## KITTITAS COUNTY DEPARTMENT OF PUBLIC WORKS

### MEMORANDUM

TO: Lindsey Ozbolt  
FROM: Christina Wollman, Planner III *CW*  
DATE: May 2, 2014  
SUBJECT: 3160 Via Kachess Shoreline Variance SV-14-00001

Sheet Title
SITE PLAN
SCHEMATIC

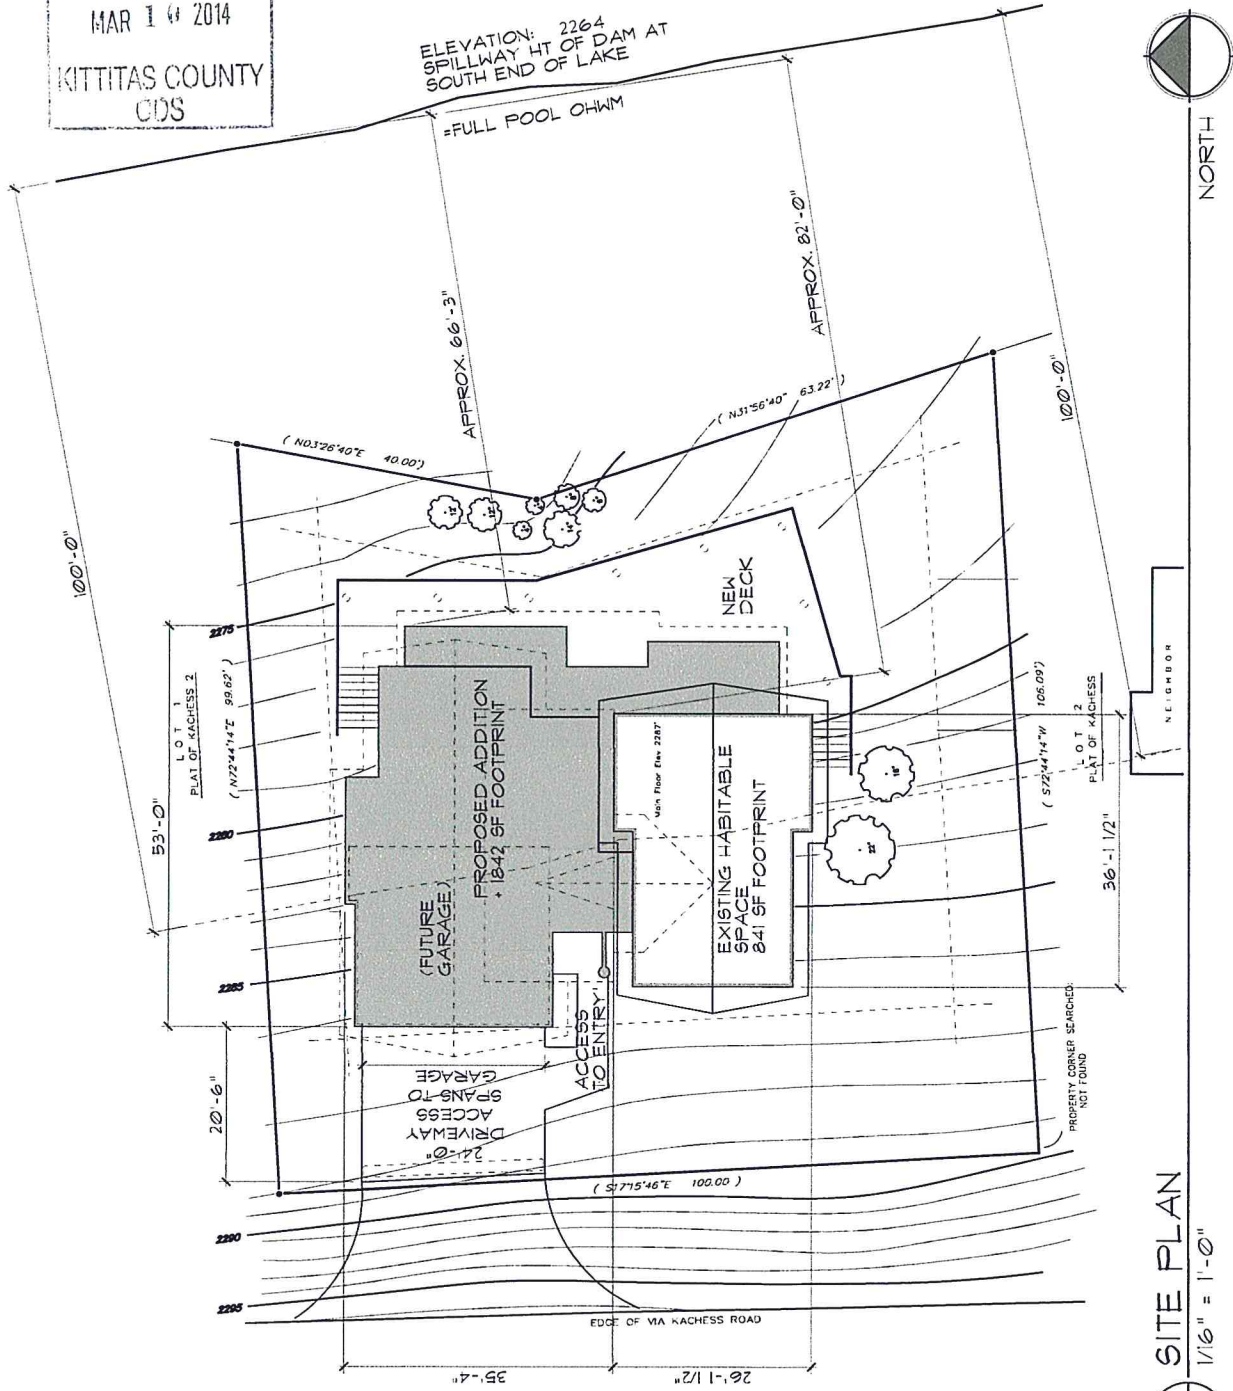
- A. Floodplain: This property received a LOMA from FEMA and is no longer considered to be within the regulatory floodplain. Case No. 14-10-0523A.
- B. Access: This project proposes a new access from the county road. An access permit must be applied for and issued prior to beginning any work within the county right of way. Access must be completed prior to issuance of a building permit.
